From: Peter Green <Peter.Green@pkct.com.au>
To: Ashley.Cheong@planning.nsw.gov.au
CC: Alex.Chalk@pkct.com.au; Mark.Beale@pkct.com.au
Date: 12/3/2012 1:42 pm
Subject: National Biodiesel Limited Soybean Crushing Facility and Biodiesel Refinery, Port Kembla – Proposed Modification (08_0083 MOPD 1) - Submission by Port Kembla Coal Terminal (PKCT)

I refer to the department's letter dated 15 November 2012 in regard to the National Biodiesel Limited (NBL) Soybean Crushing Facility and Biodiesel Refinery, Port Kembla – Proposed Modification (08_0083 MOPD 1). Port Kembla Coal Terminal (PKCT) offers the following submission.

Figure 9  
Location of Frog Exclusion Fences

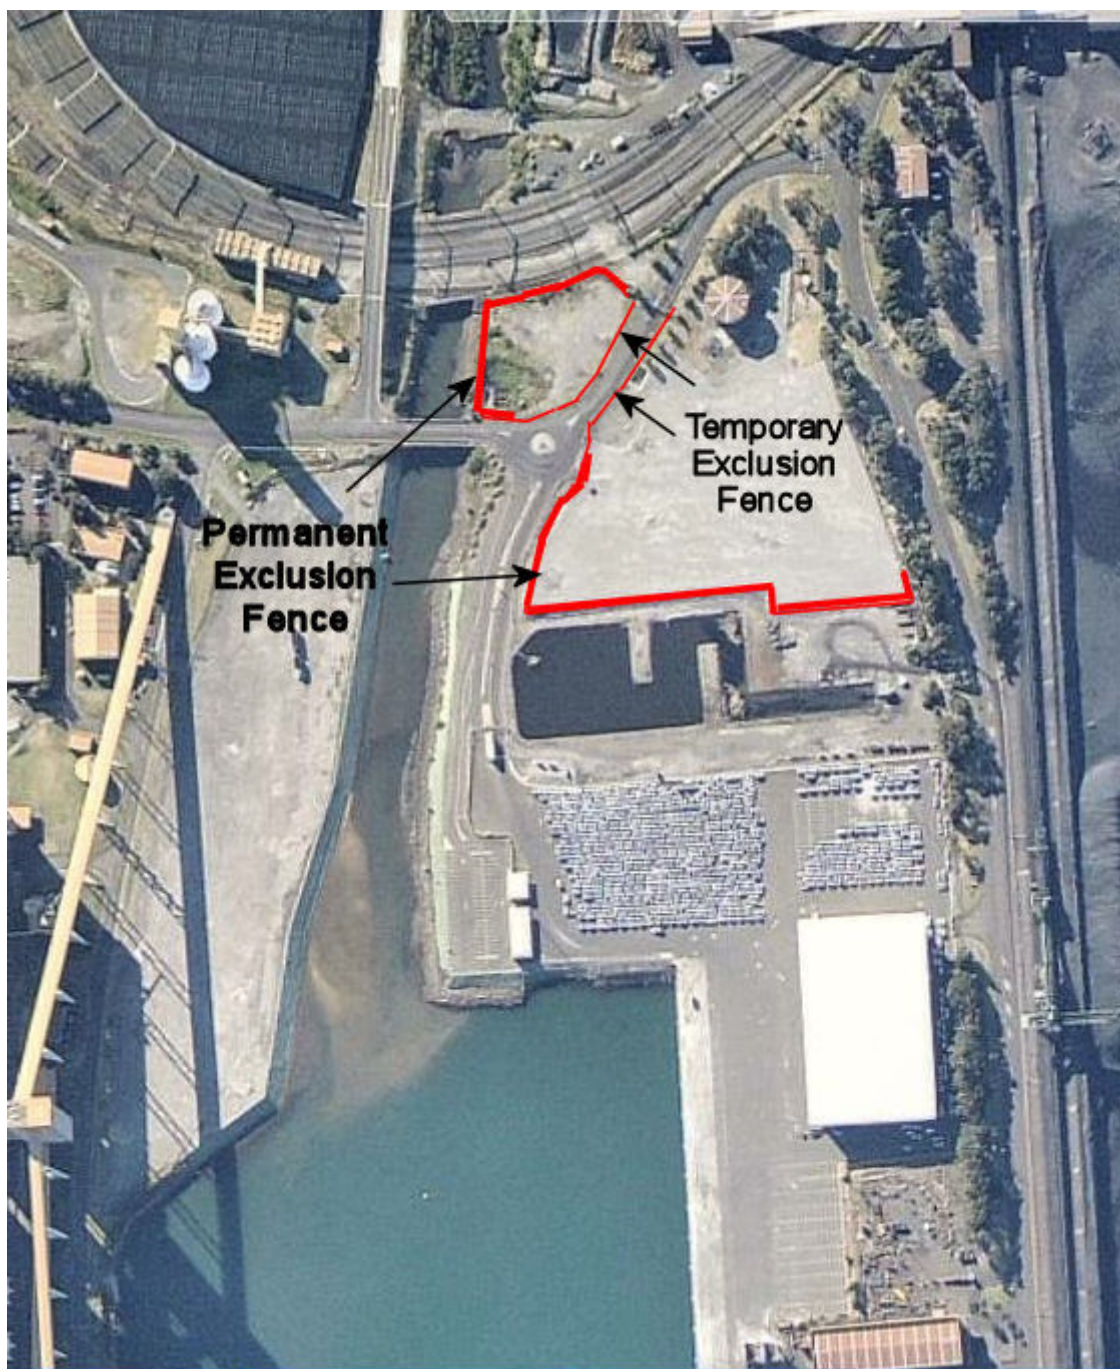
2. *PKCT has reservations about the potential risks associated with chemical, fuel and other liquid spills on the proposed NBL site, especially considering the close proximity to PKCT's settling lagoon. How is NBL going to ensure that potential offsite impacts affecting PKCT do not eventuate in the near term and additionally as the proposed plant infrastructure ages?*

PKCT comment/submission – PKCT's main item of concern is the close proximity to the south of the proposed refinery plant to our final stage water treatment pond (settling lagoon) and licenced discharge point . This will require diligent and detailed consideration across the comprehensive planning, design and execution works; and across the longevity of the planned operations. PKCT has a number of operational, safety and environmental obligations which we would like to ensure are appropriately managed into the future. We are committed to ensuring these obligations are met within an already challenging industrial/urban/environmental context, we are therefore wary of any new developments which have the potential to introduce environmental and other management issues. We therefore trust that NBL will implement best practice controls, as appropriate, to mitigate any potential impacts to our site and operations.

- It is intended to install a retaining wall and associated security fence and frog exclusion fence on the southern boundary adjoining the PKCT settling pond so that the land for Plot 3 is stabilised and secured, as it sits higher than the adjoining PKCT land.

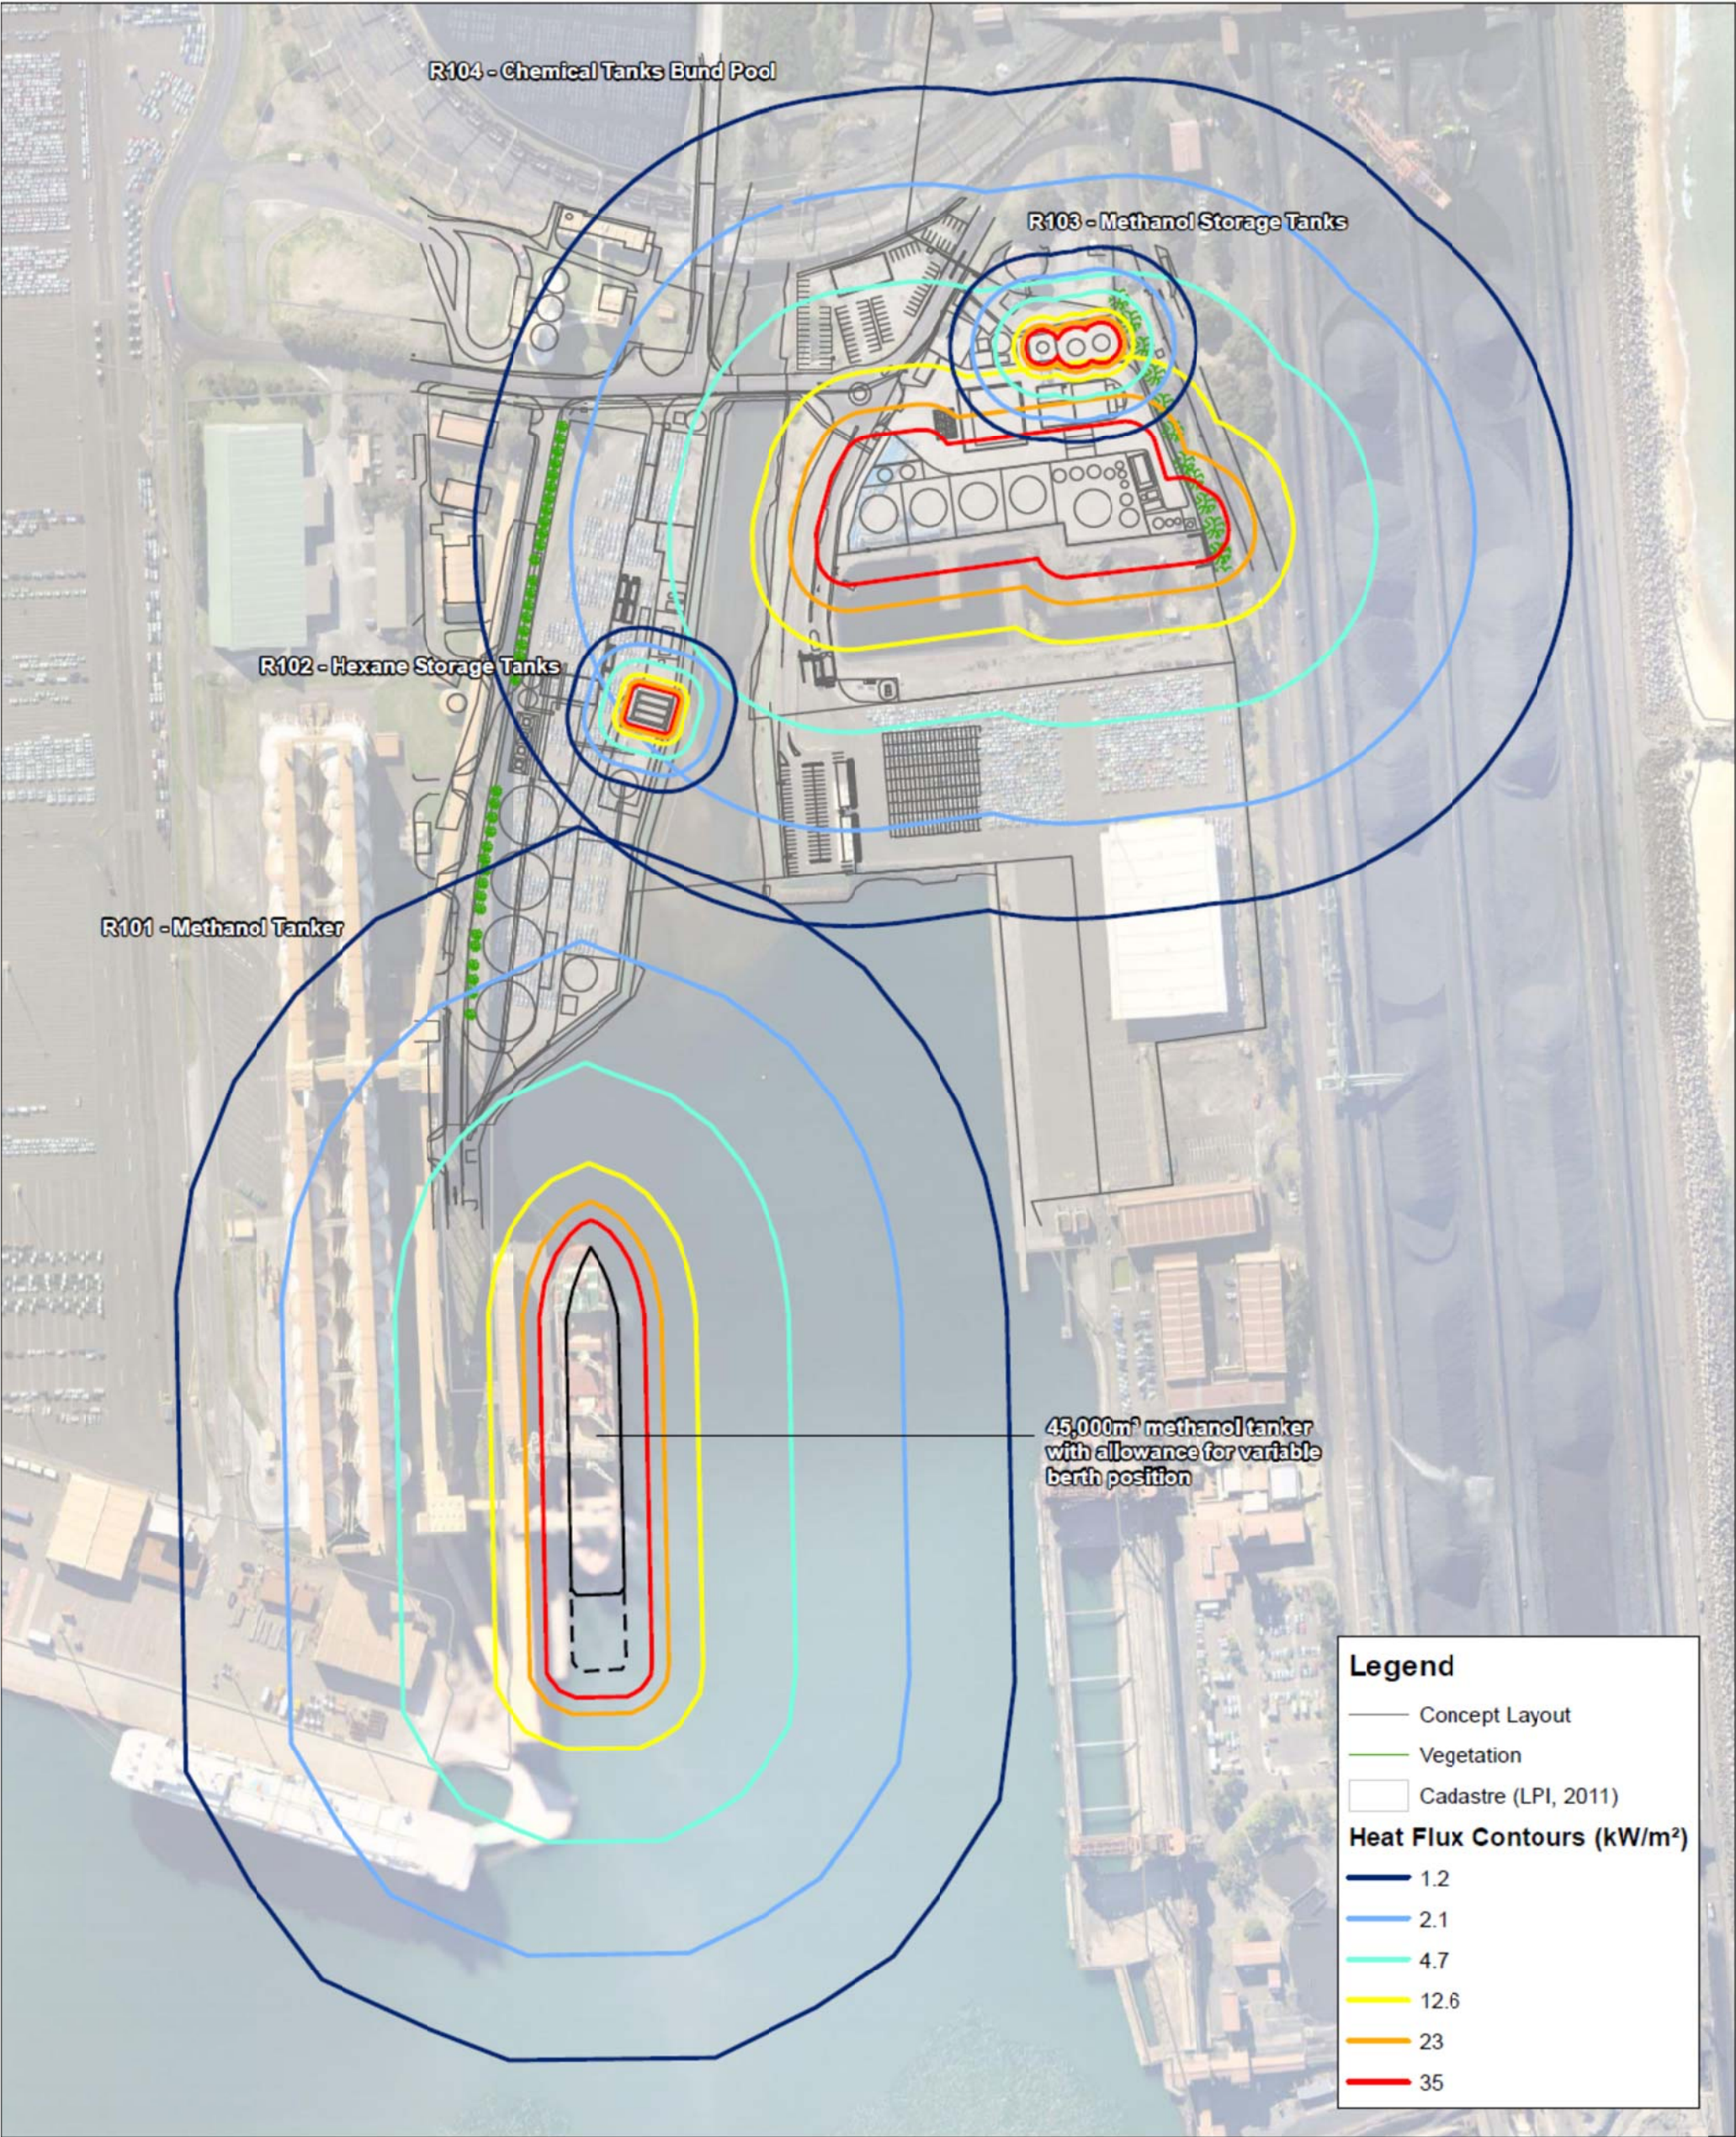
3. PKCT need assurance that in the unlikely event of a liquid fuel or chemical storage tank fire, combustibility of PKCT's coal stockpiles or damage to other infrastructure will not be a concern. Can NBL provide a written response in relation to this concern that will provide PKCT with some comfort?

PKCT comment/submission - We need to be certain that over time facility conditions, or maintenance budgets do not lead to a deterioration of the proposed controls replied to by NBL. E.g. fire system.

- Revised heat flux diagrams were developed for the new Plot 3 as part of the hazards and risk assessment, focusing on potential fires from the bulk storage of flammable and combustible liquids. (note: the volume of liquid contained in the manufacturing facilities piping and equipment is considered negligible as compared with that in the bulk storage tanks).

- These revised heat flux diagrams have shown that the radiant heat impacts meet the relevant risk criteria – i.e. that the heat flux is such that personnel on neighbouring sites can safely evacuate the area in the event of a fire before there is any risk to personal safety.

- The risks from a fire from the methanol or sodium methylate tanks are mainly contained on Plot 3. The heat flux effects on the neighbouring PKCT water tank and pump house are negligible; the modelled heat flux is a maximum of 4.7kW/m^2 at the edge of the water piping compound and near the edge of the western side of the PKCT access road, which is well below the threshold of 12kW/m^2 at which plastic will melt or vegetation will burn. The heat flux at the PKCT water tank, pump house and the eastern side of the PKCT access road is 1.2kW/m^2 which is equivalent to being out in the hot sun in the middle of summer.

- In the extreme worst case, as modelled in the radiant heat flux diagrams, the modelled heat flux at the closest PKCT stockpile is below 12.6kW/m^2 , the threshold at which plastic will melt or vegetation will burn.
